**Glebe Island Expo**

**Interim Exhibition Facility**

**Glebe Island and White Bay**

**Submission by Leichhardt Council**

CAR PARK C
SCALE 1:1000

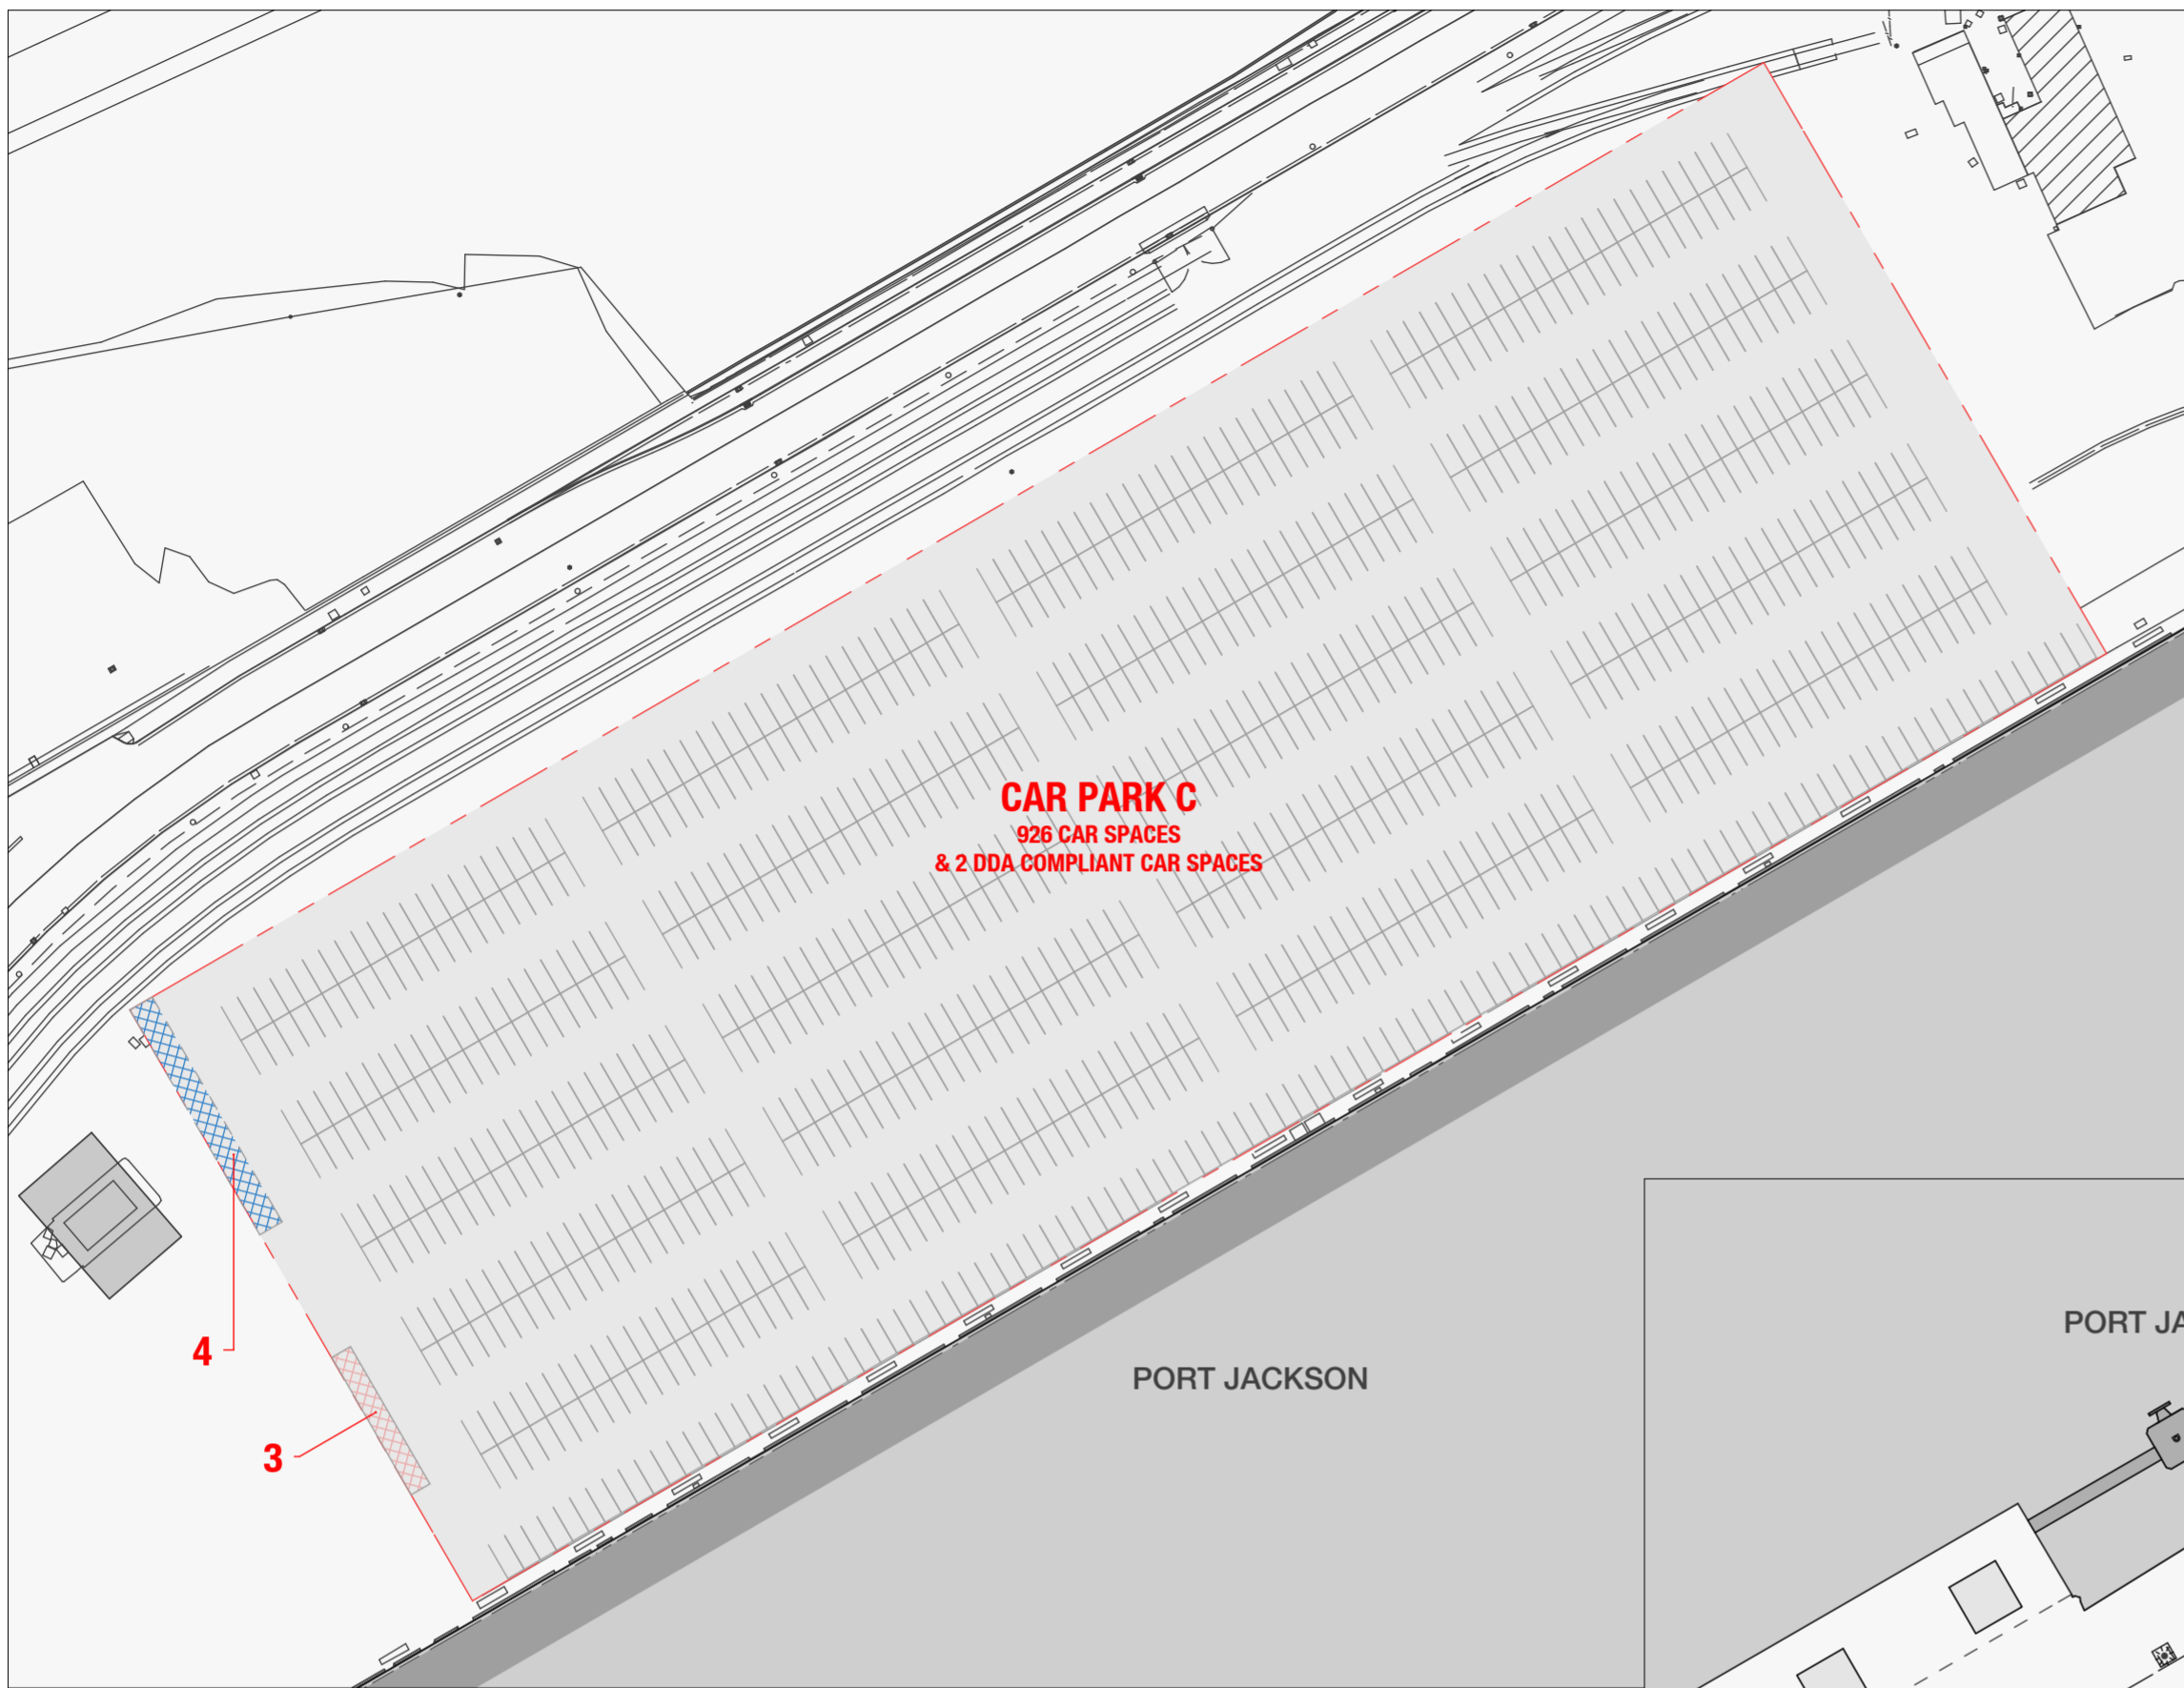
- Deletion of the proposed road link between the Glebe Island site and Robert Street Rozelle in order to avoid unacceptable impacts on the local traffic network, key intersections and the existing street parking

- The exclusive use of James Craig Road for all vehicular access and egress to the facility, including all car parking and delivery vehicles
- Further analysis of the transport, traffic and car parking impacts of the development and update of transport and traffic management plans in response
